Application No.: 16/00472/OUT

Proposal: Proposed residential redevelopment for approximately 200 units

Location: S Grundon Services Ltd
Merton Street
Banbury
OX16 4RN

I write with regard to the above referenced planning application and following our previous meetings on 17th July and 20th August 2020. I have now had opportunity to review the responses to the latest round of consultation and as promised, I am writing to confirm the position of officers.

3. masterplanning. appropriate scale and sense of place

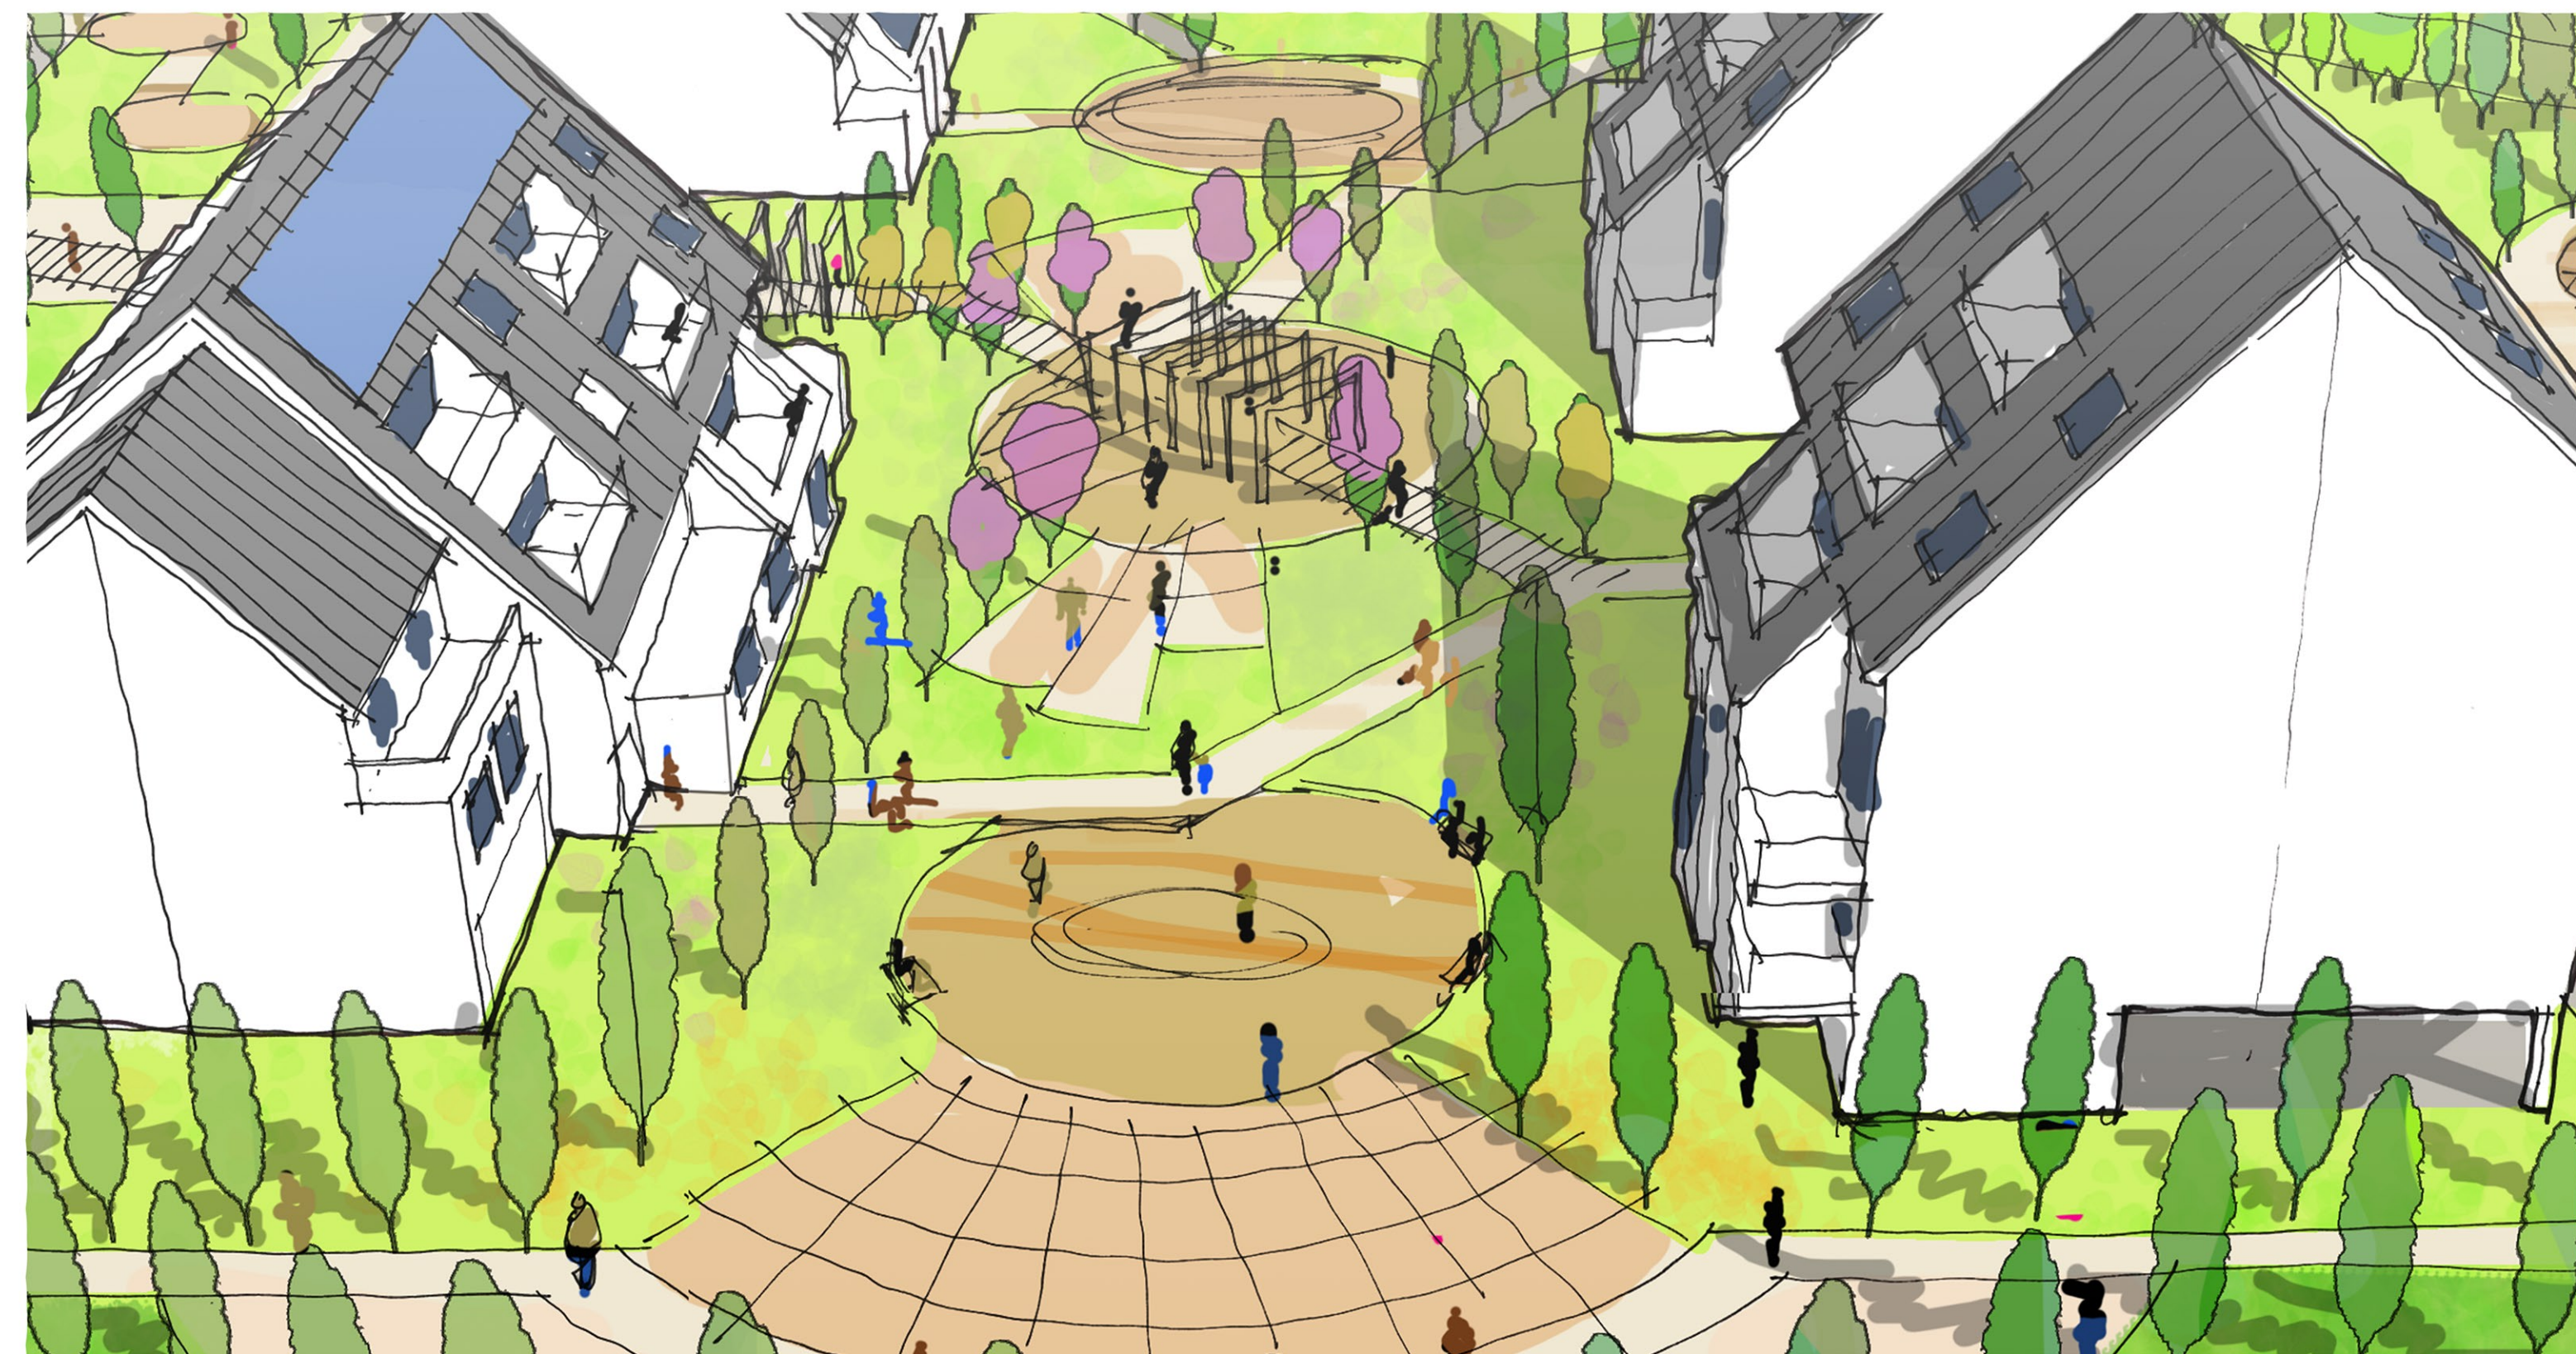
The Council's Landscape Officer has advised that the 6m high bund required to mitigate the noise impact would be: *visually harmful and physically oppressive for residents. The feature would require extensive landscaping mitigation, along with a 3m wide maintenance access route along its length.* The Council would not adopt this feature and the arrangements for maintenance of this feature need to be addressed in the planning obligation.
